Engineers comments for BR/266/12/

APPLICATION **BR/266/12/**

Site Address: 28 & 30 Corbishley Road Bognor Regis West Sussex PO22
9HR

Description of Works: Erection of 2 no. 2 bed dwellings and 1 no. 3 bed dwelling and
formation of 3 no. parking spaces.

Block Plan scale 1:200

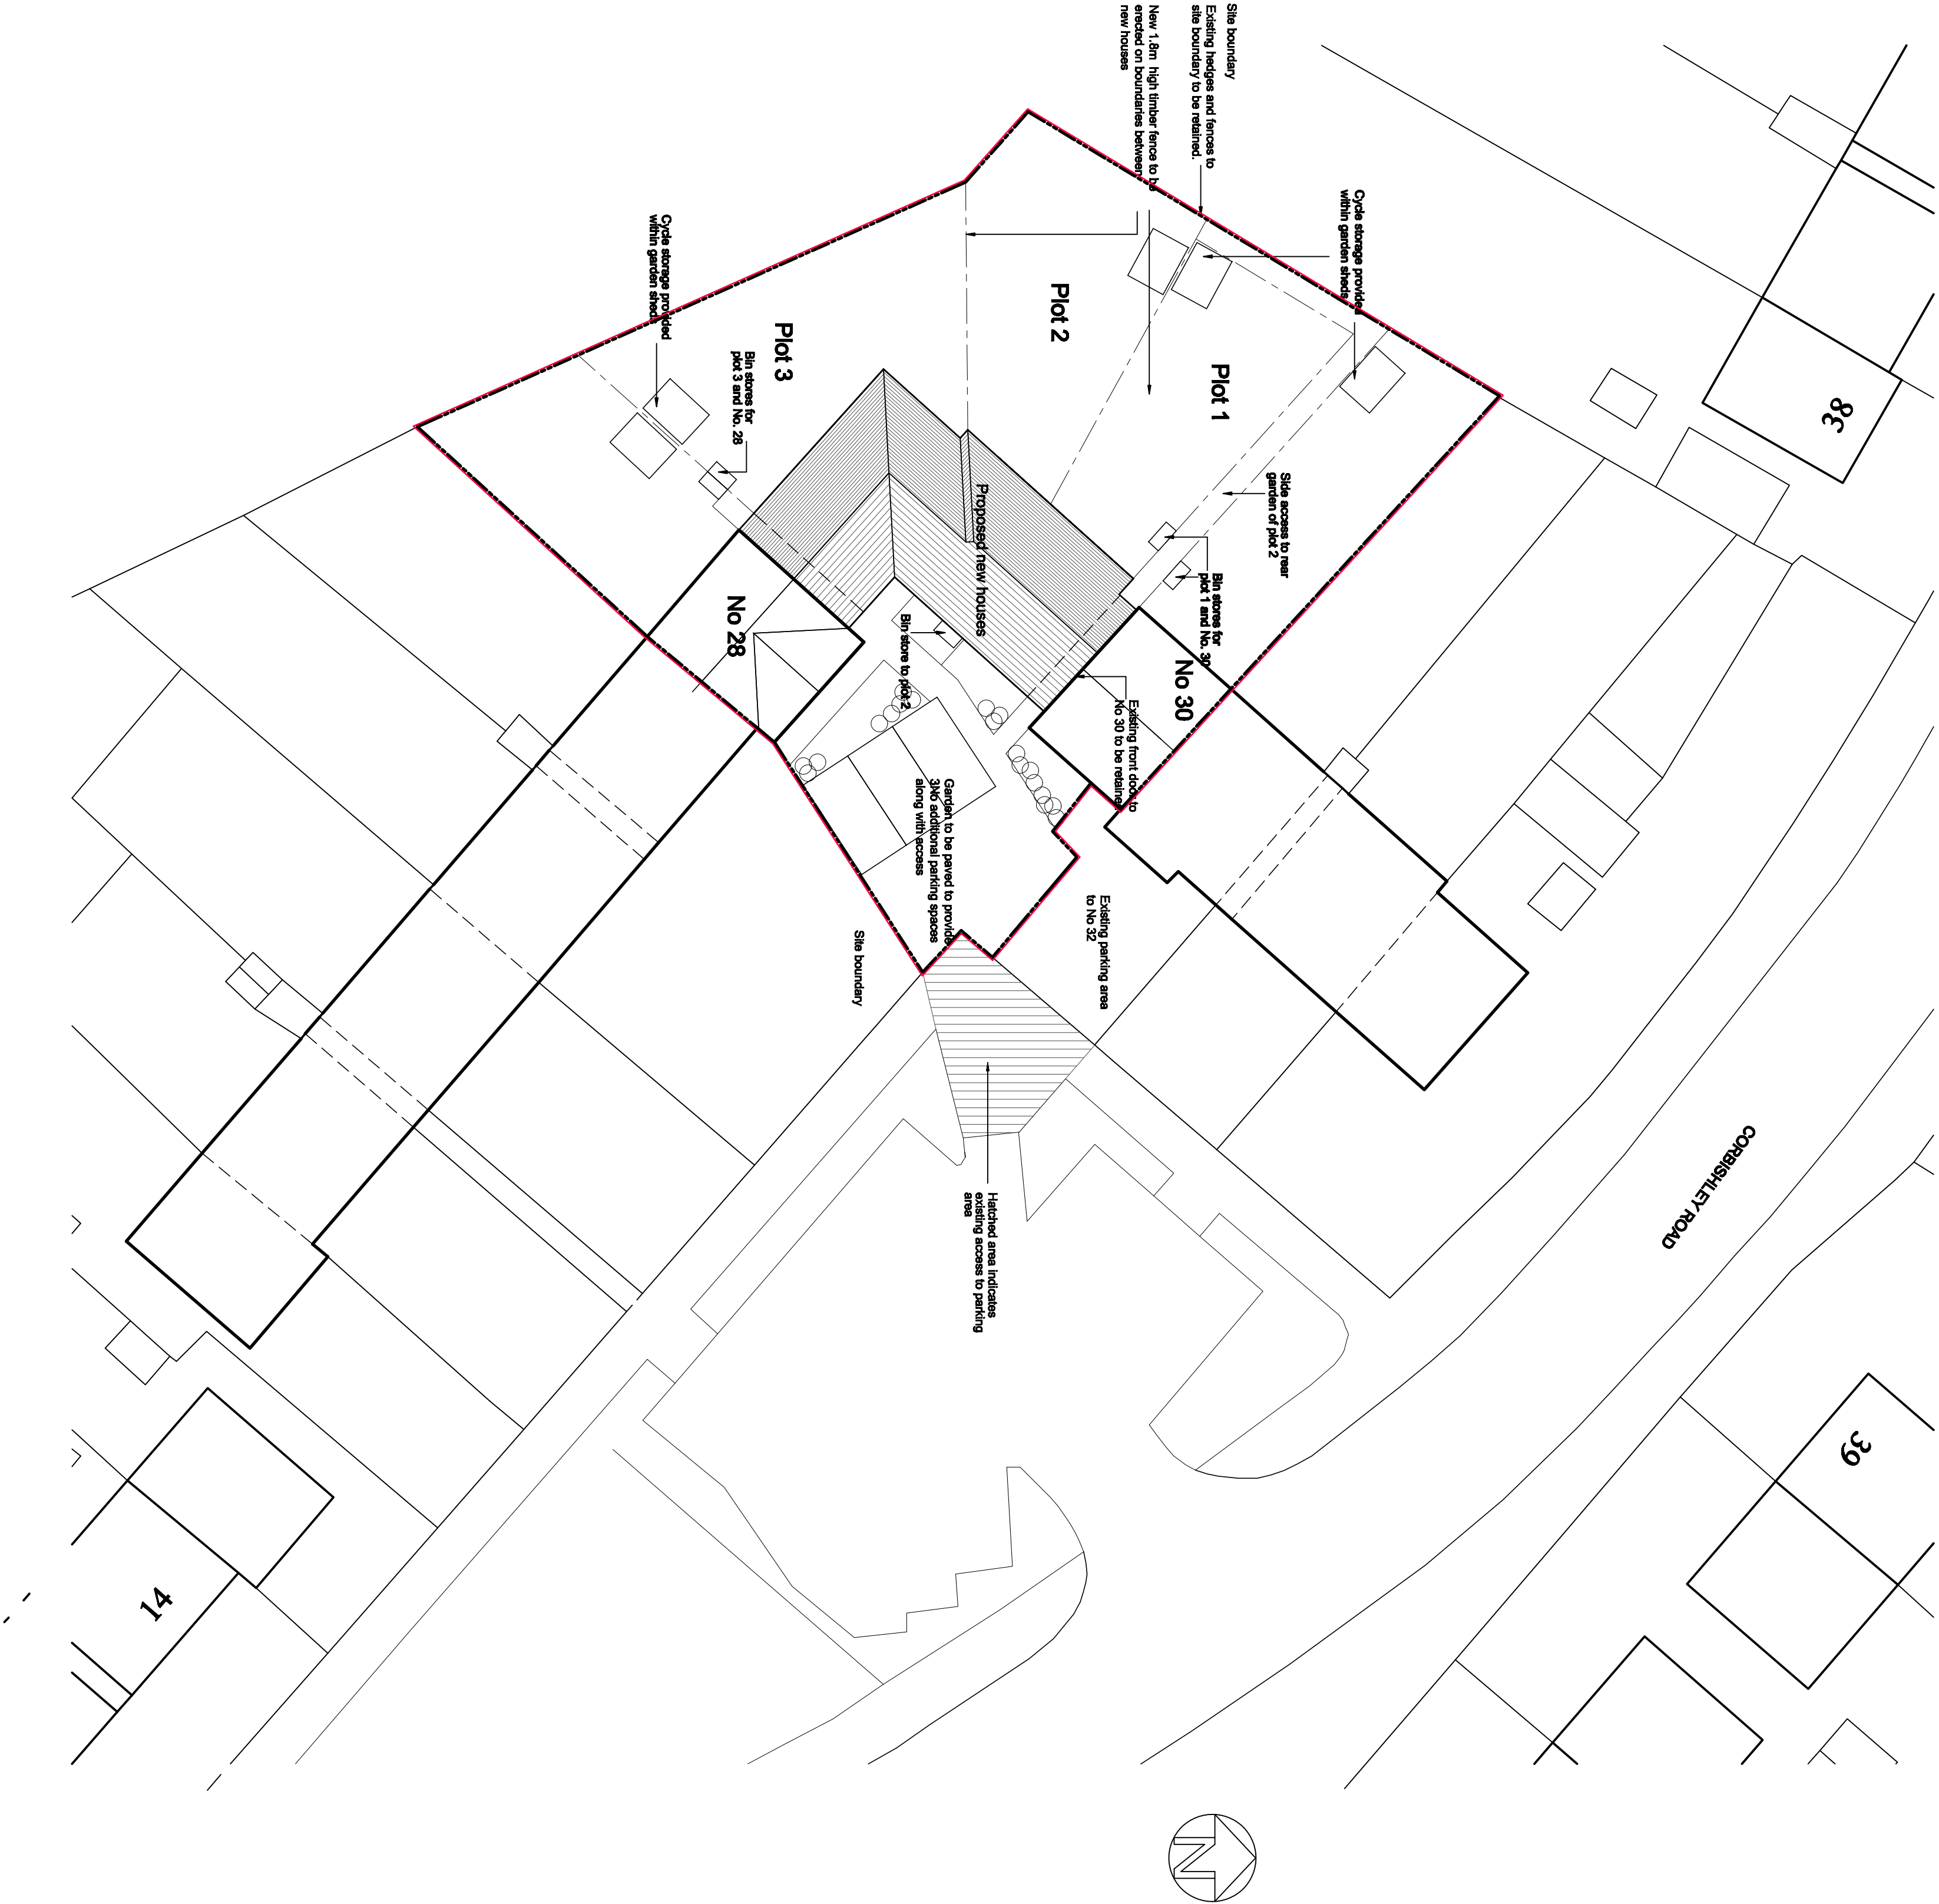
There is a high probability that there is a public foul sewer on this site, if this is the case and the building proposals are over or within 3m of a sewer then a formal agreement will need to be sought with southern water. Construction of soakaways will not be allowed within 5 m of any sewer/drain. Exact locations of existing surface water and foul water system will be required to discharge the surface water condition.

Development shall not commence until full details of the proposed surface water drainage scheme have been submitted to and approved in writing by the Local Planning Authority. Existing surface water system and foul water system must be included with this submission. The design should follow the hierarchy of preference for different types of surface water drainage disposal systems as set out in Approved Document H of the Building Regulations and the SUDS Manual produced by CIRIA. Groundwater monitoring to establish highest annual ground water levels and Percolation testing to BRE 365, or similar approved, will be required to support the design of any Infiltration drainage. No building shall be occupied until the complete surface water drainage system serving the property has been implemented in accordance with the agreed details.
